RE: QuikTrip Store #4299 Final PUD Plan and QuikTrip 4299 Subdivision Filing No. 1 - Final Plat Applicant Responses

Thank you for the comments dated November 1, 2021 regarding the subject development application under Final PUD and Final Plat review. We appreciate you working with us to resolve the comments since their issuance; below is a summary in ***bold and italics*** of our responses that coincide with our related plan revisions.

SHEET TITLE:  
SITE PLAN (SOUTH)

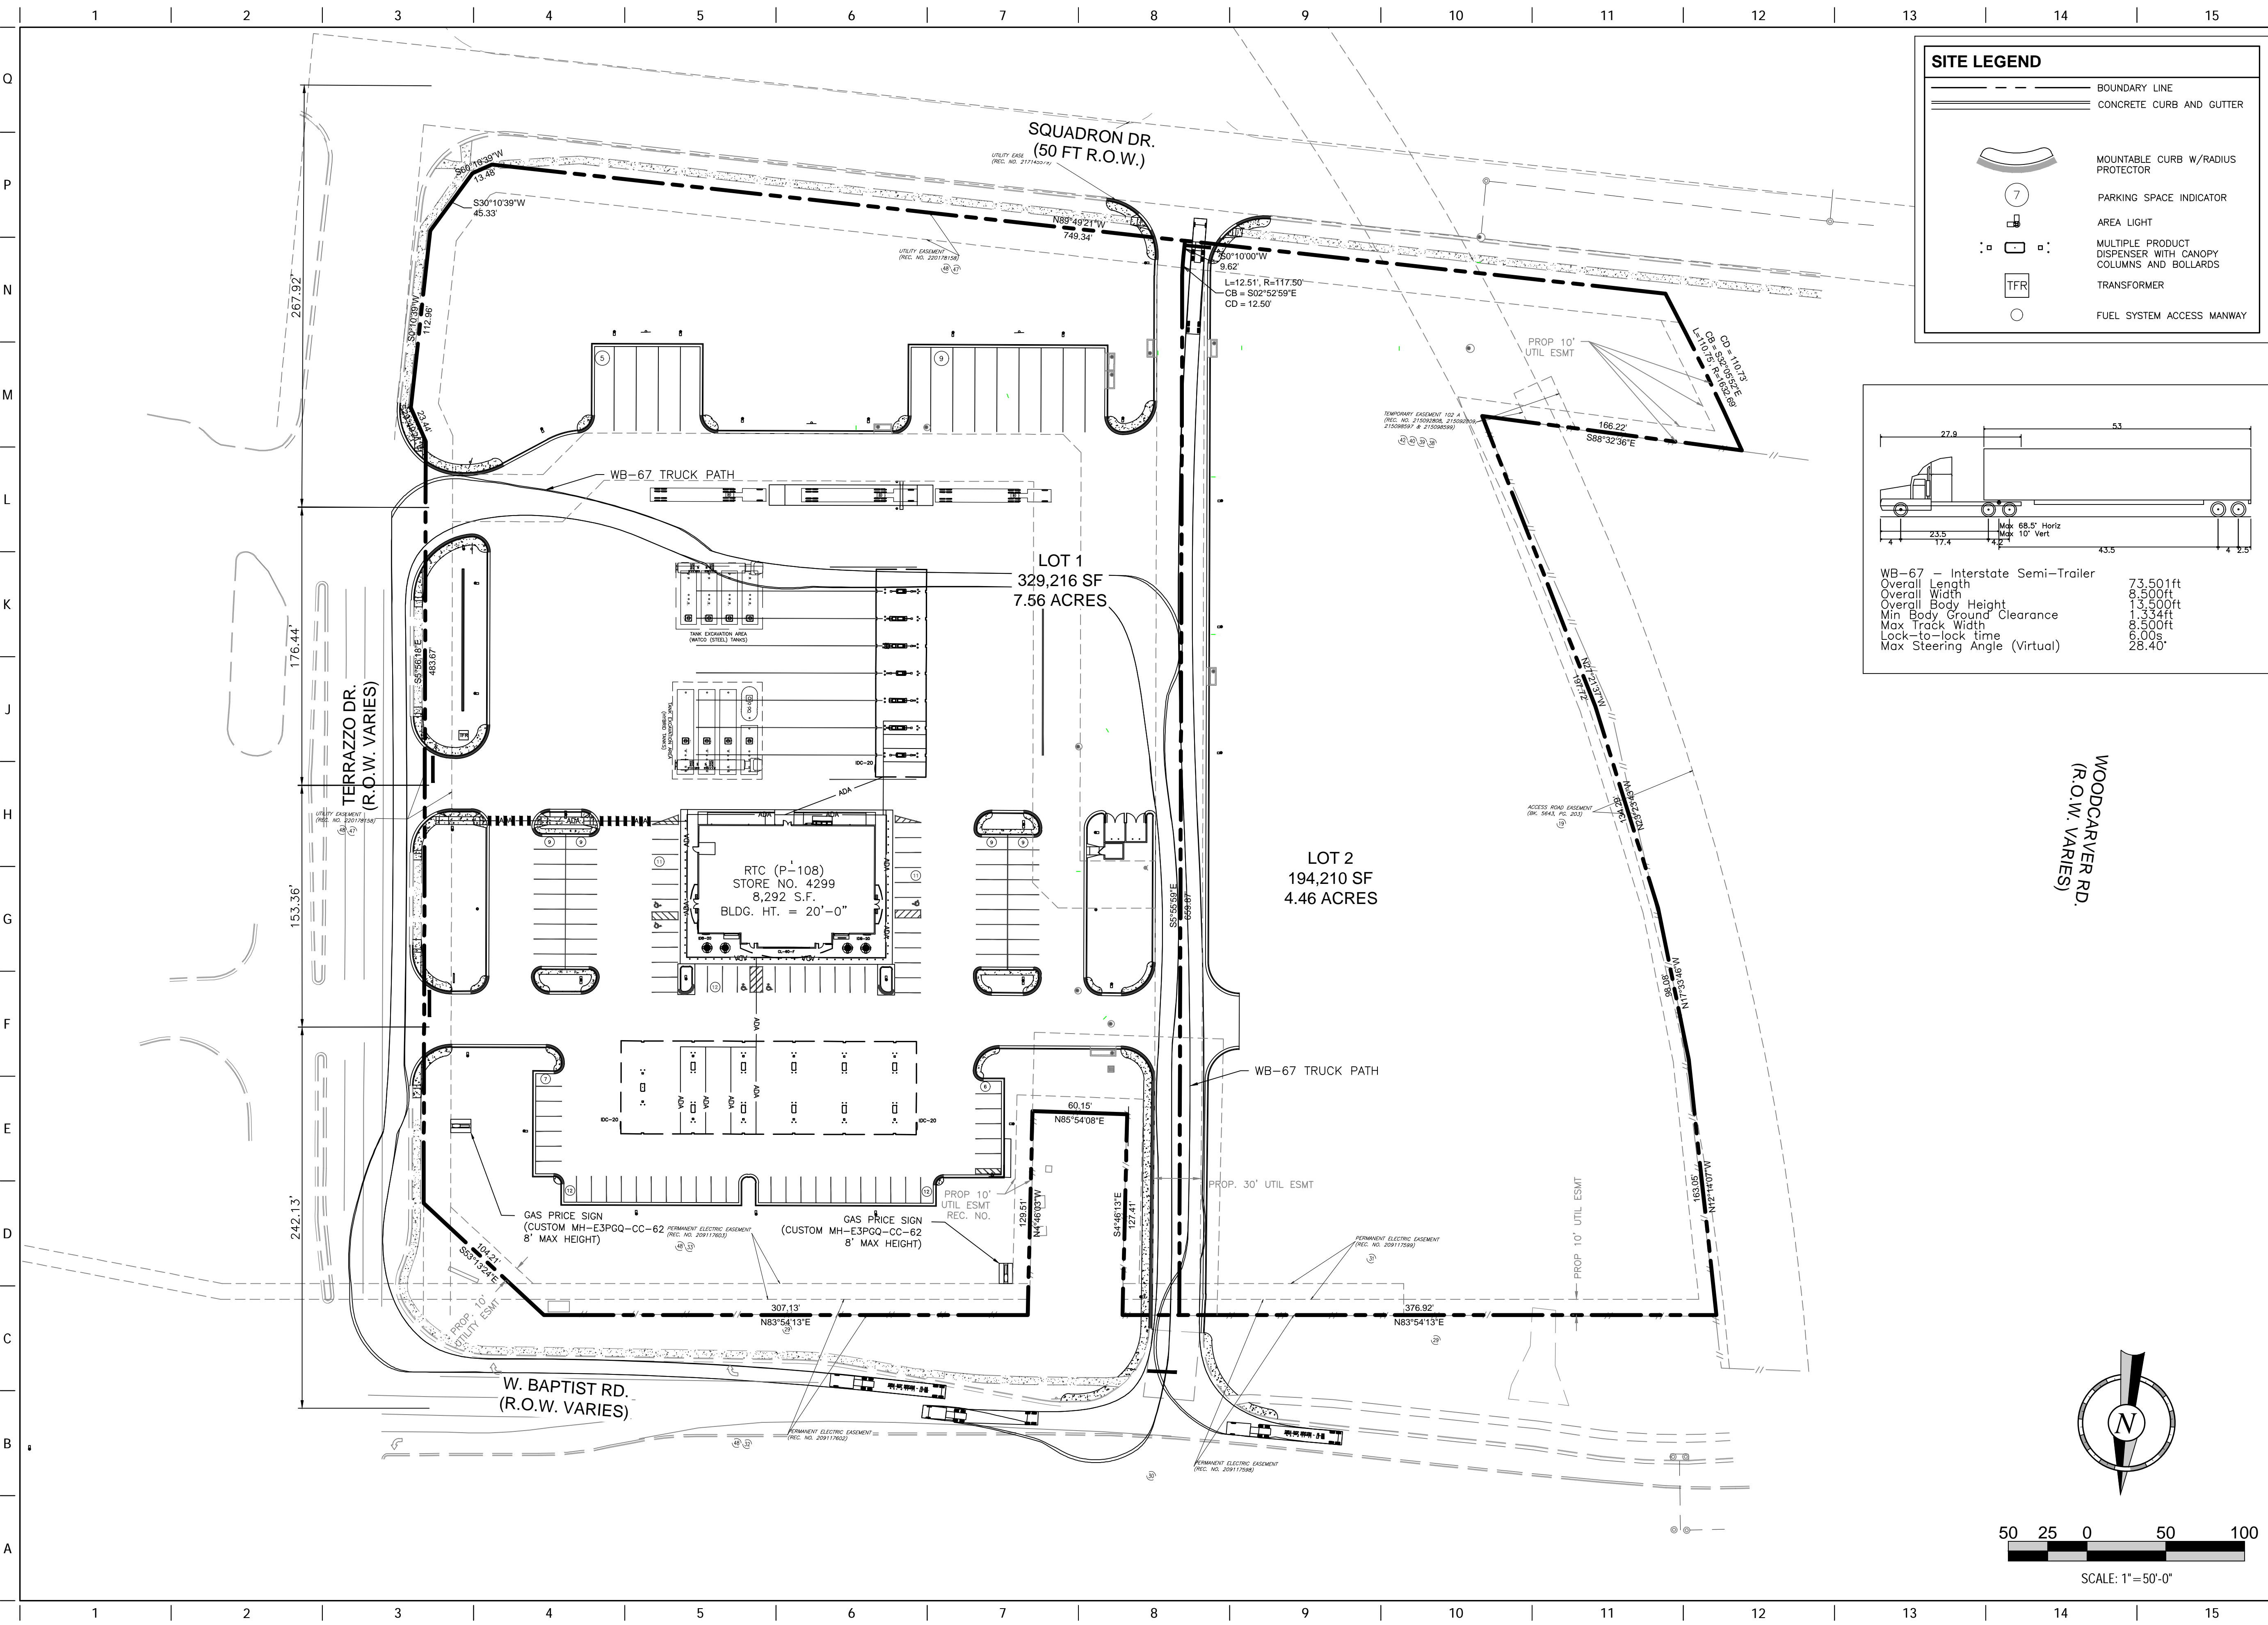
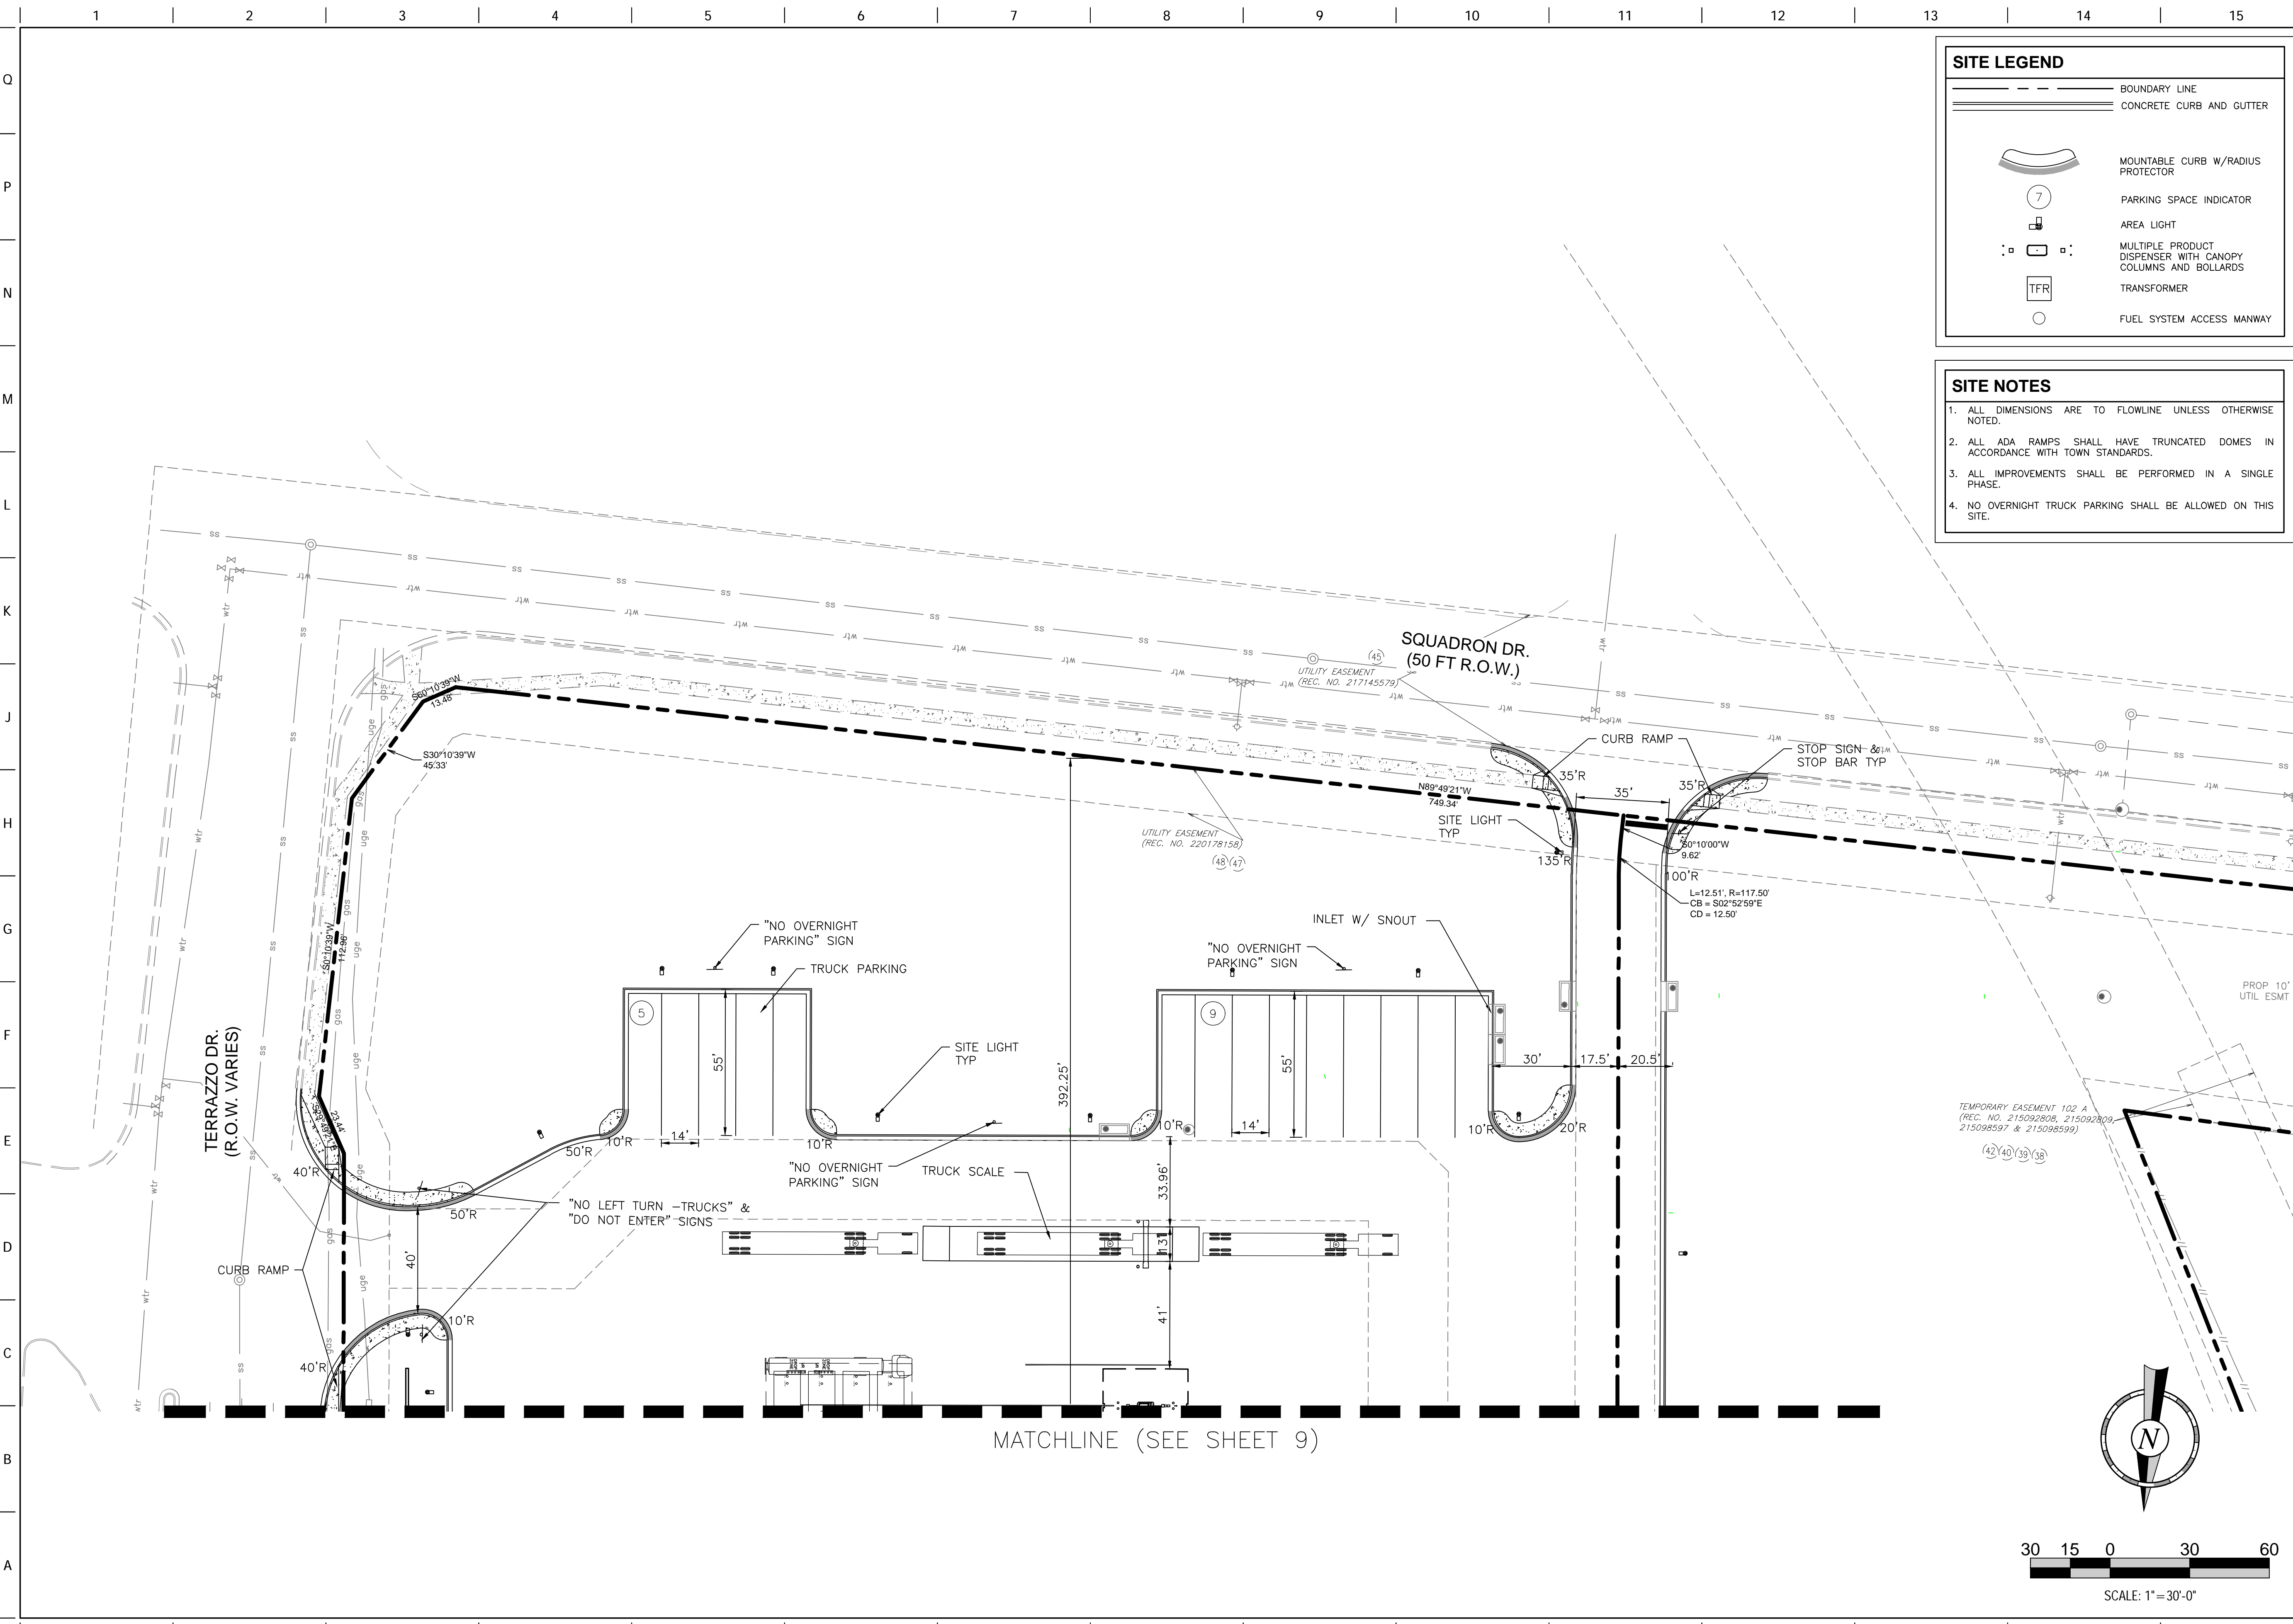
Site Plan (Sheet 9):

16. Please call out your signs by stating gas pricing sign.

a. Does QuikTrip require two gas pricing signs?

17. Please turn off water, sewer, etc. lines.

18. There is no need to show the previous Old Denver Road. It is an obsolete road.

19. Please show the building square footage.

20. Please show the sidewalk along Terrazzo Drive.

Galloway Response: A gas price sign is preferred along each roadway frontage. These two signs have been called out as gas price signs. Understood, thank you for the information regarding sign height and permitting. This will be kept in mind when signage is finalized.

Galloway Response: Understood, proposed and existing utility lines have been turned off of this sheet.

Galloway Response: Understood, Old Denver Road has been removed from the plan set.
